Modification 5 Five Ways – Design Modifications - SSD-66826207-Mod-5

DPHI letter dated 12 June 2026

Project No.
19073
Dwg No.
DA-310-101

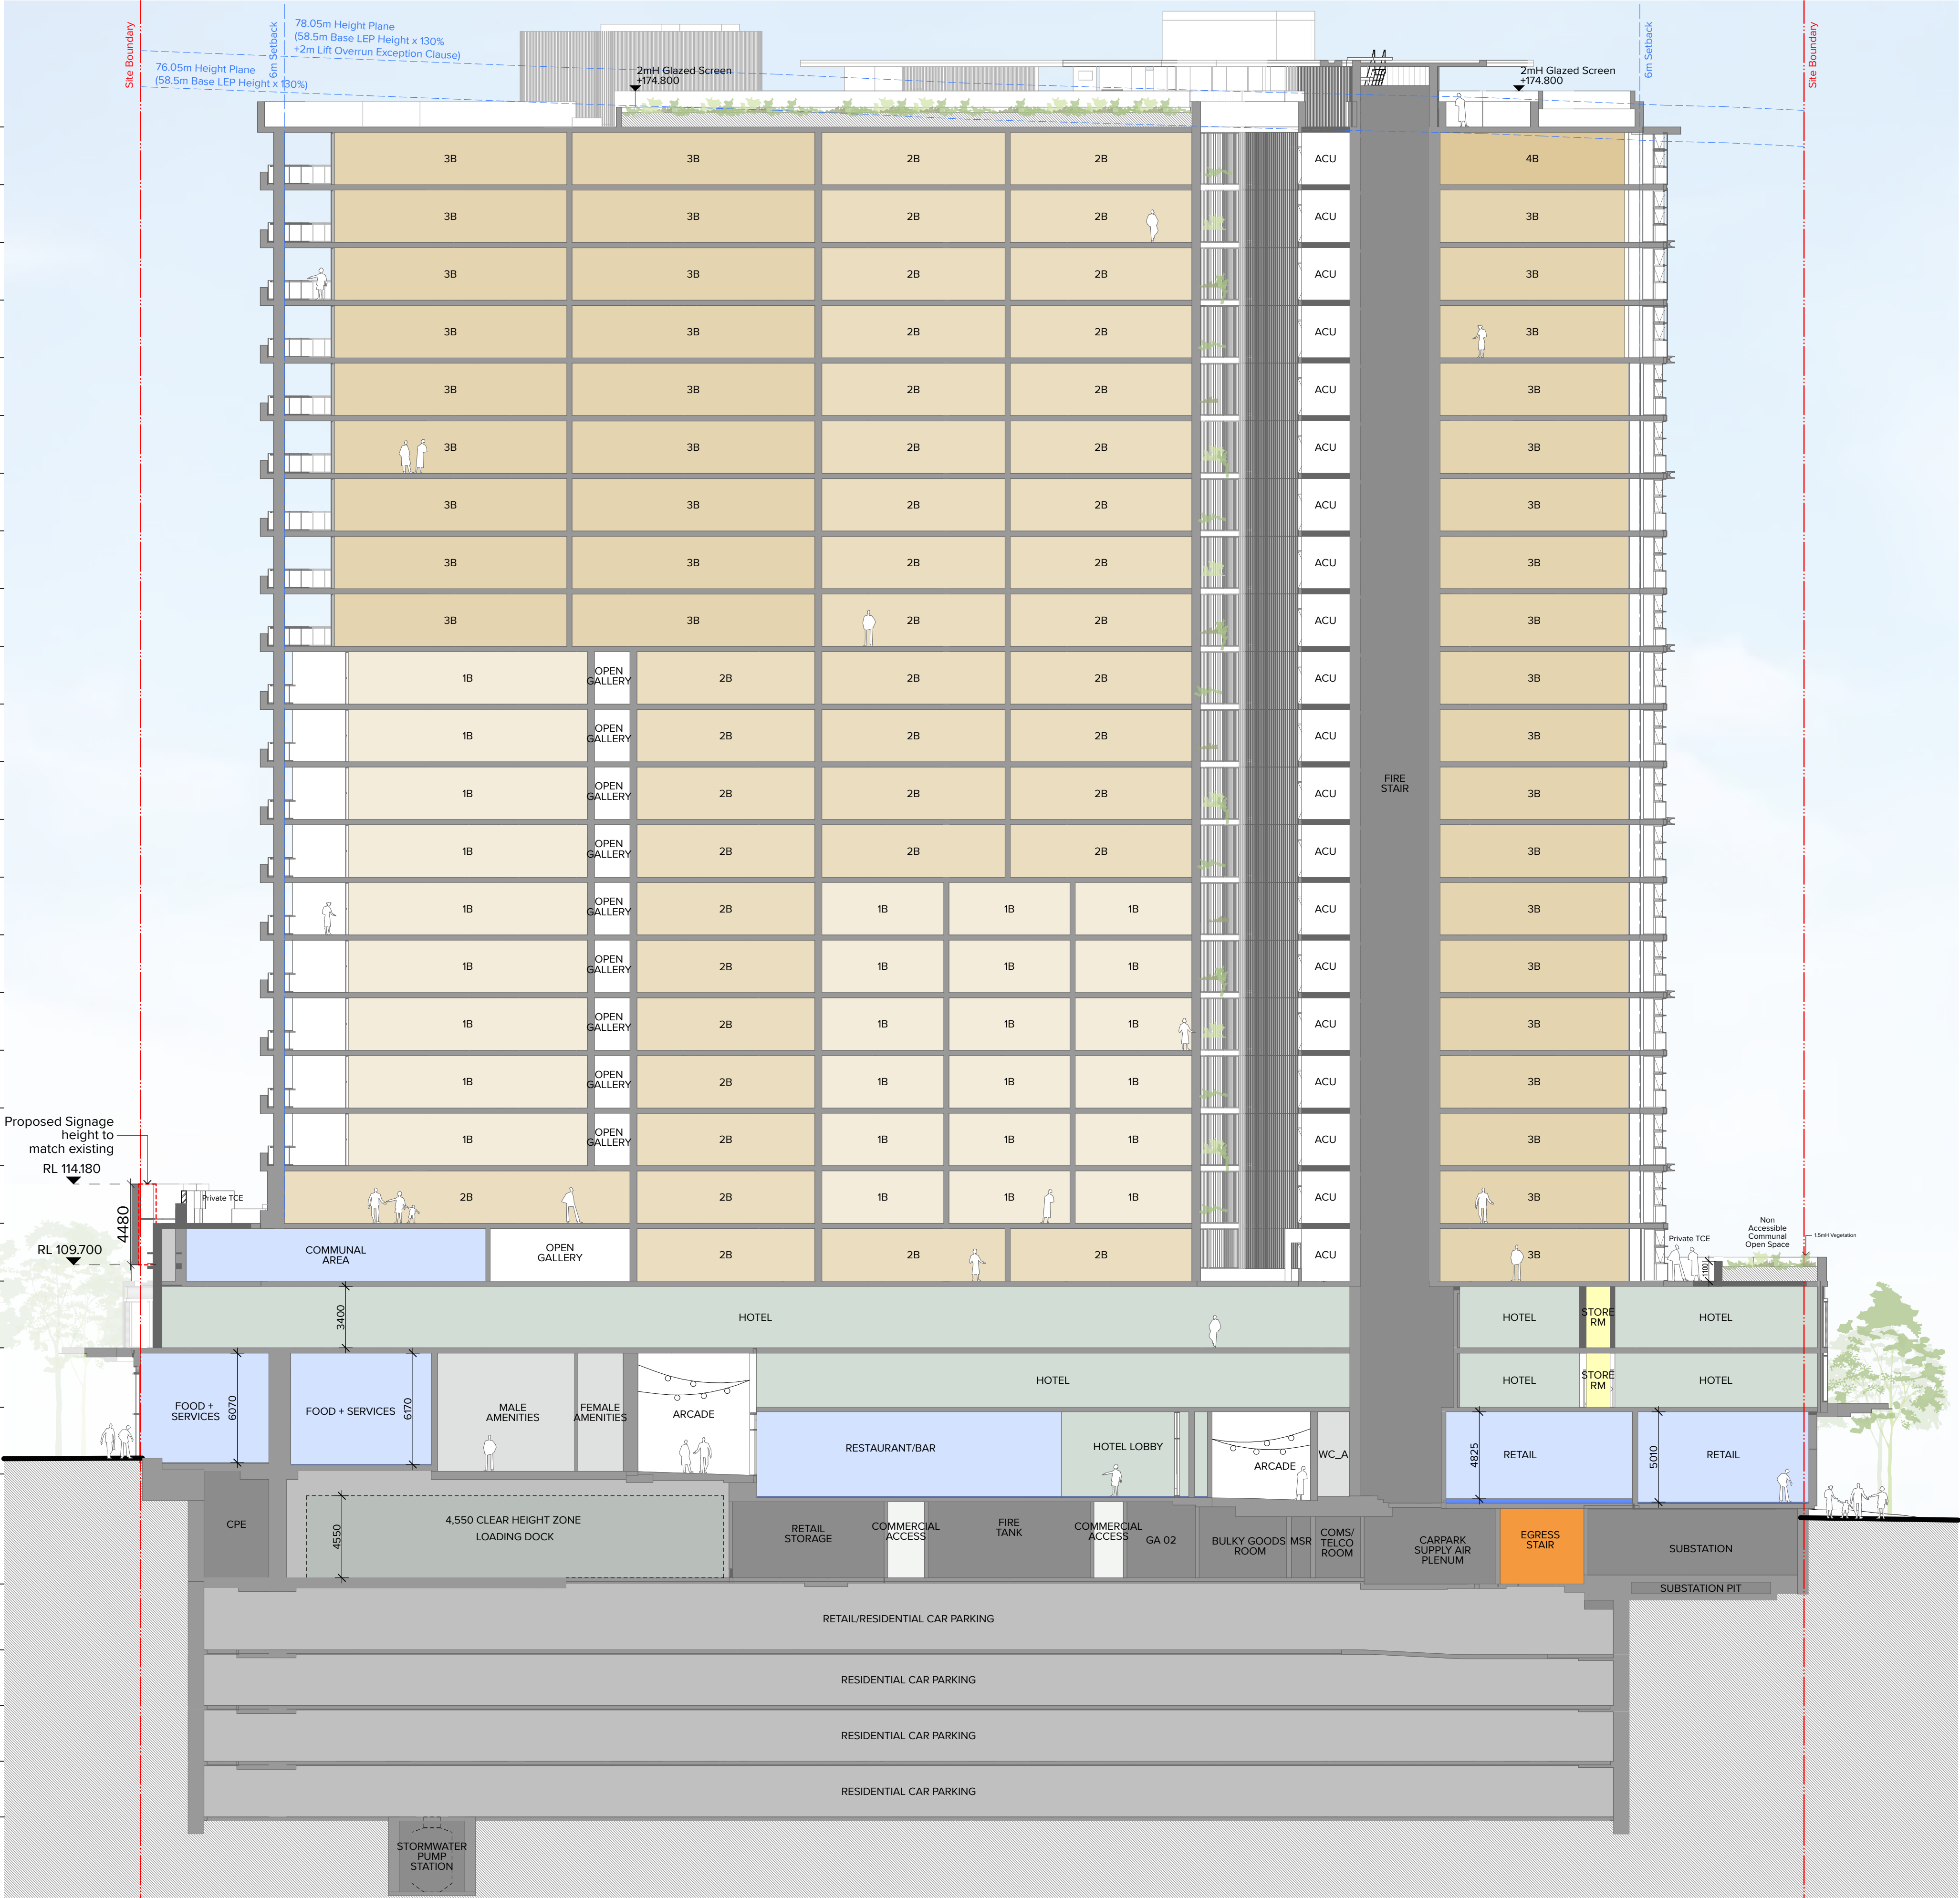
The shadow diagrams provided do not demonstrate the extent of overshadowing resulting from the proposed increase in building height under this modification application.

Additionally, please we have included in our submission amended sections (drawings DA-310-101 to DA-310-301) showing 5 levels of basement.

Project No.
19073
Dwg No.
DA-790-005

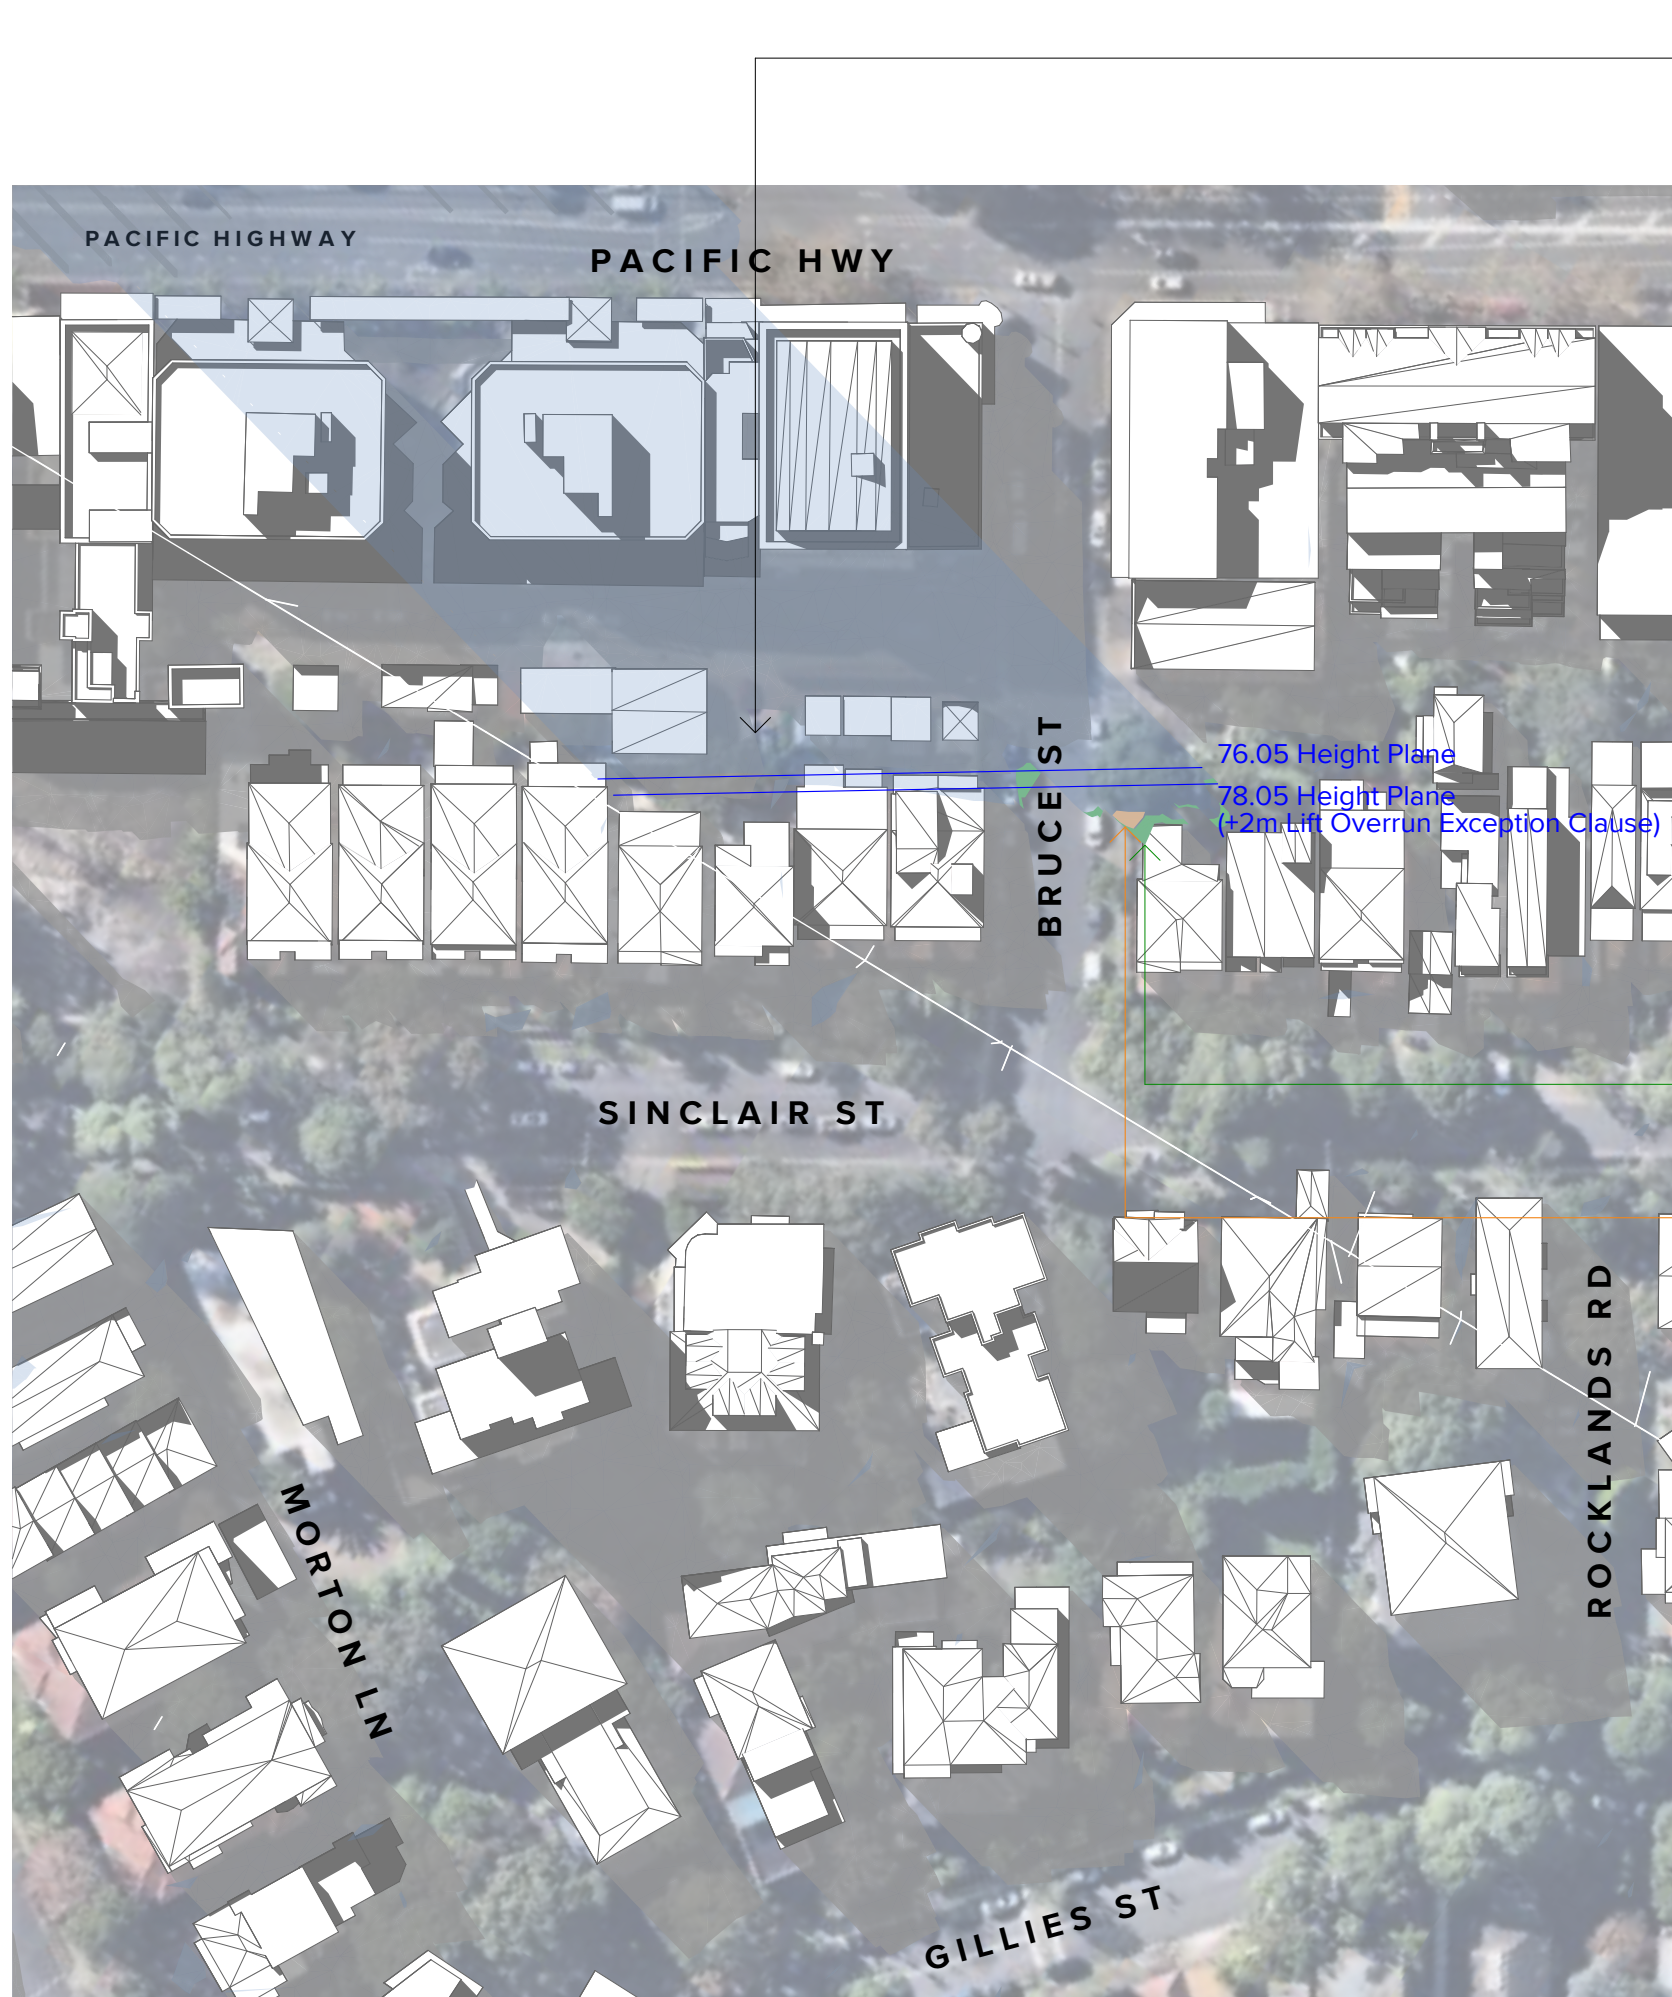
Revised shadow diagrams are required that must encompass surrounding areas, including any impacted residential properties, the Holtermann Estate, and North Sydney Girls High School.

The shadow diagrams (drawings DA-790-001 to DA-790-008) created by TURNER Architects have been

updated to provide a clearer breakdown of the additional overshadowing resulting from this modification compared to previously approved version. This assessment concludes that the minor increase in height has a negligible impact on the adjoining properties including North Sydney Girls School. For further detailed explanation, please refer to the table below.
